EF16/2911, DOC 17/95221-01  
SSD 7534 MOD1

**SSD 7534 MOD1 – WESTERN SYDNEY STADIUM STAGE 1 (DEMOLITION)**

I am writing to you in reply to your invitation to the EPA to provide a submission in respect of the application to modify the consent for stage 1 of the project.

Figure 5: Areas Requiring Remediation

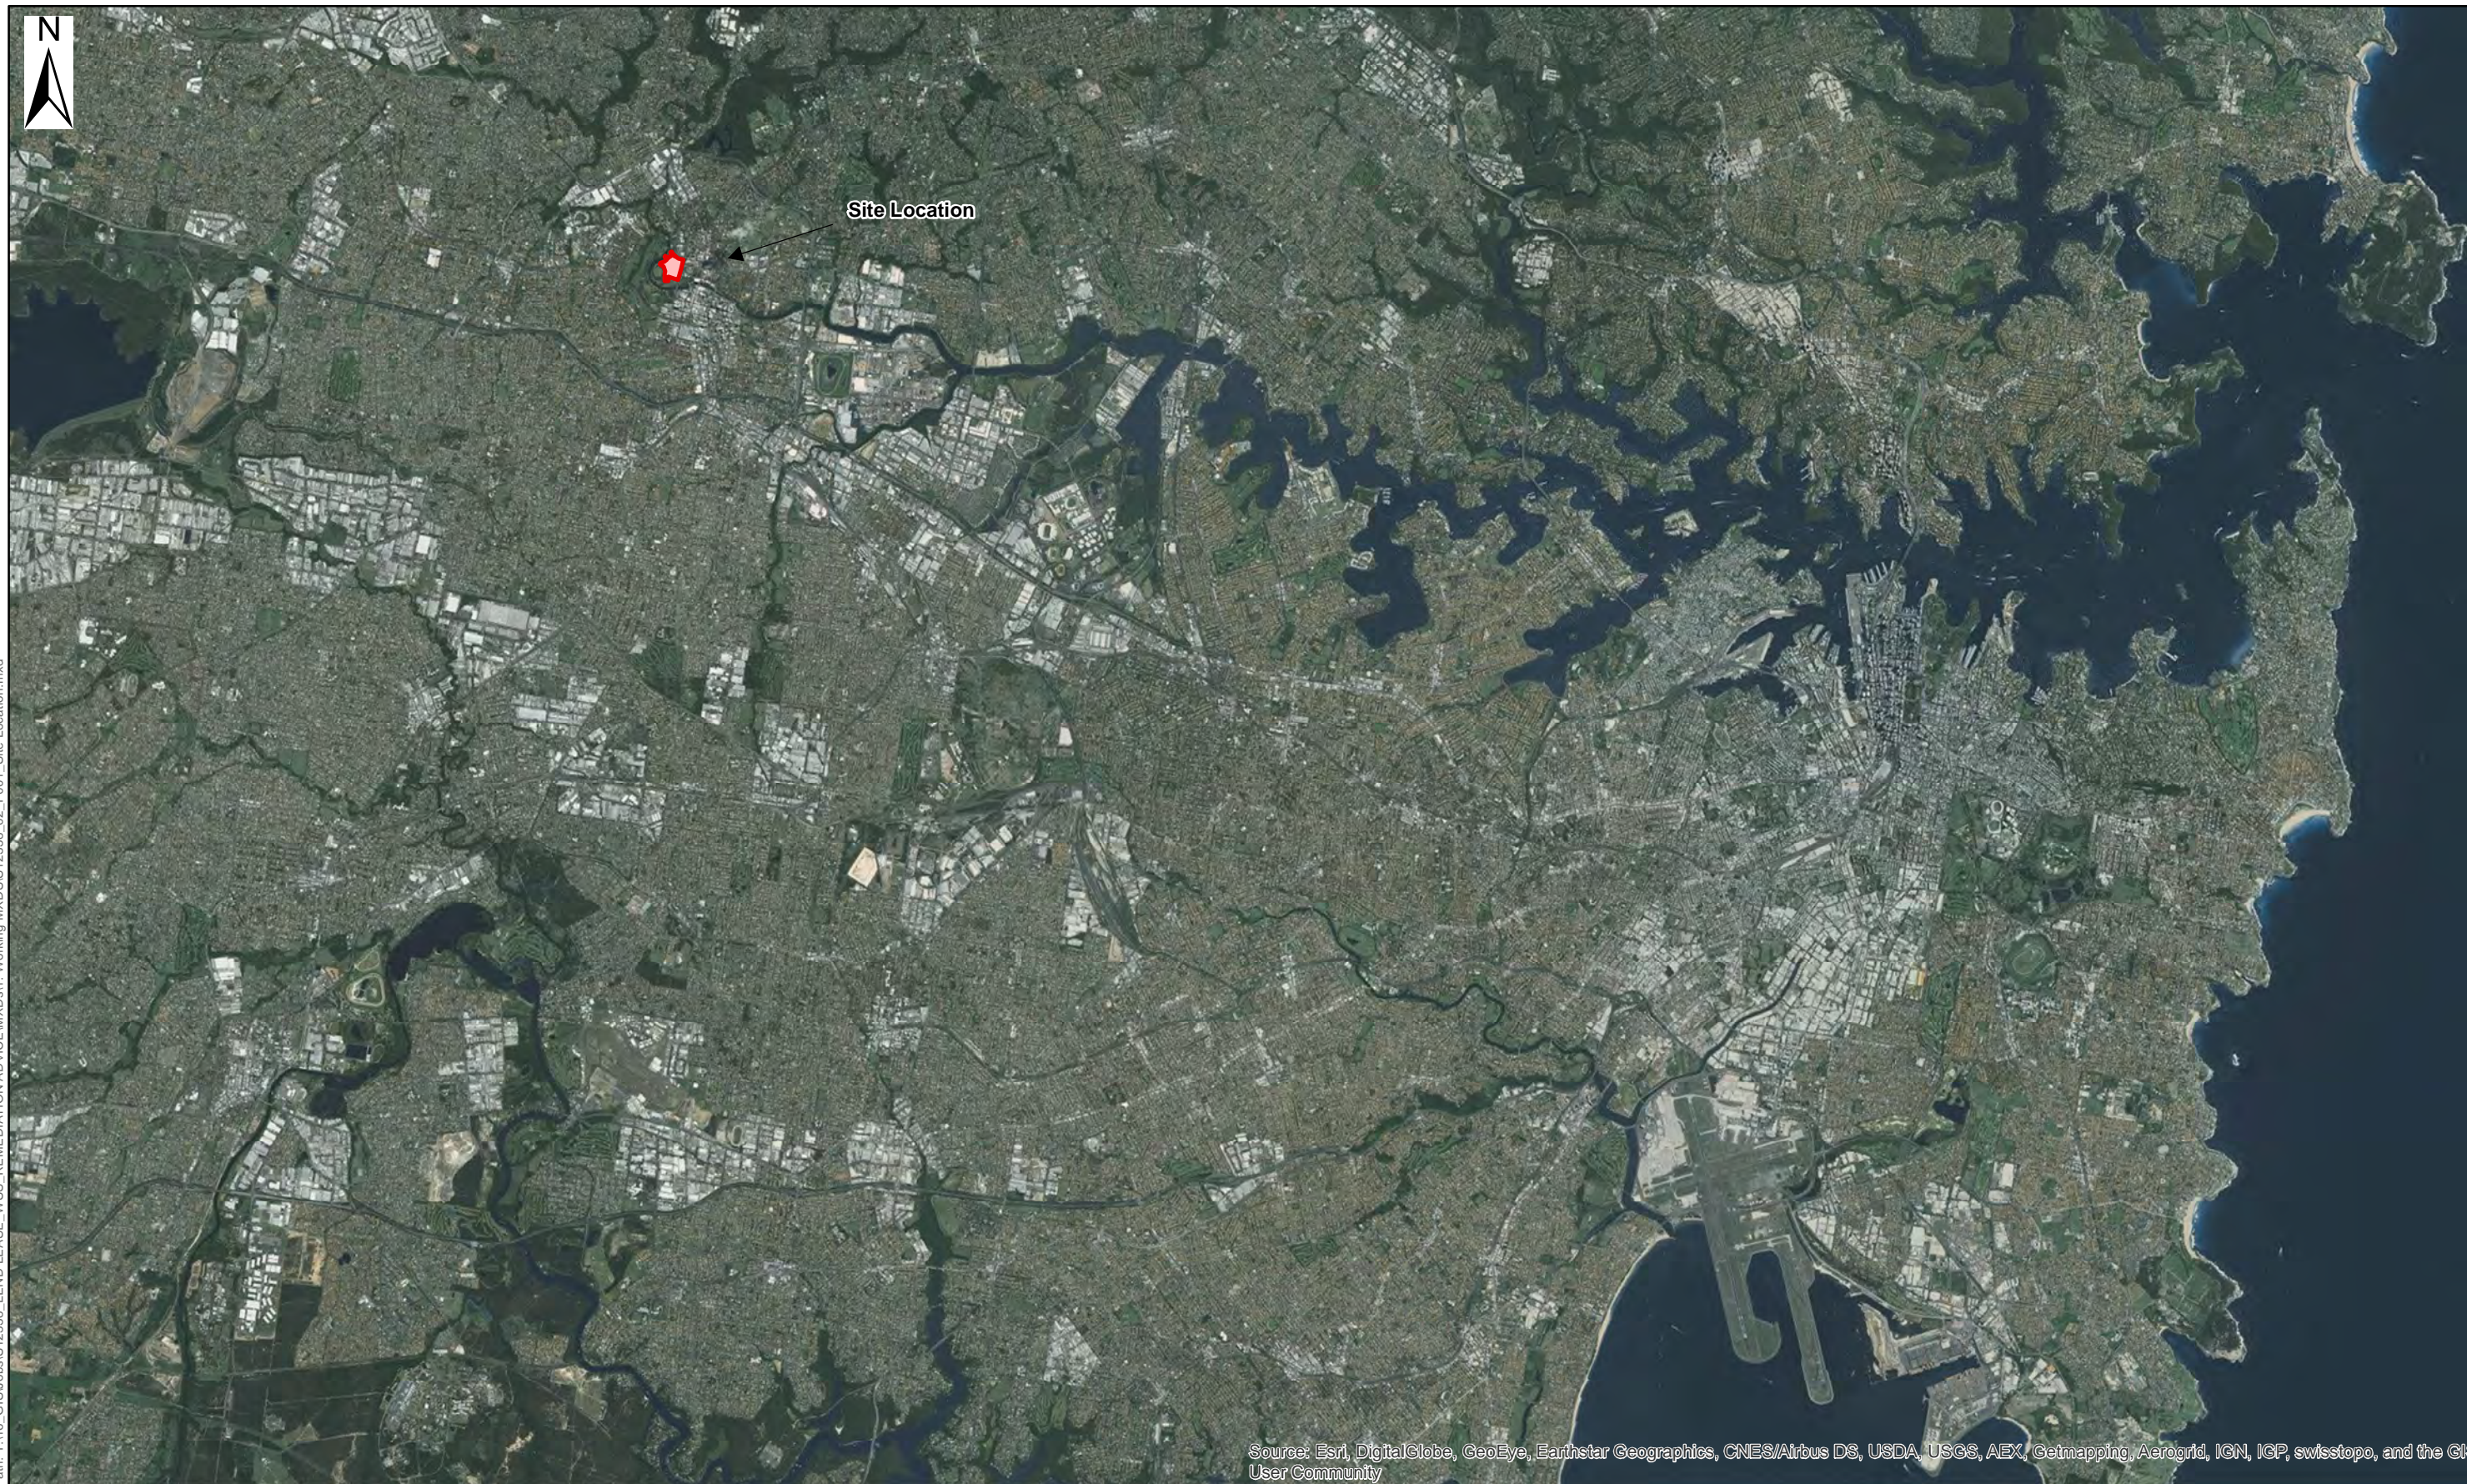
The EPA understands that a site auditor accredited under the *Contaminated Land Management Act 1997* has been engaged for the project. The Remedial Action Plan for the site proposes that contaminated fill material will be excavated and re-buried on site under a 'capping layer', comprising a marker layer and a minimum of 0.5 metres of clean material.

The proponent be required to ensure all services and service trenches lie above the proposed marker layer to minimise any risks to workers undertaking future repair and maintenance of those services.

The proponent be required to ensure all clean material to be used for the capping layer comprises virgin excavated natural material.
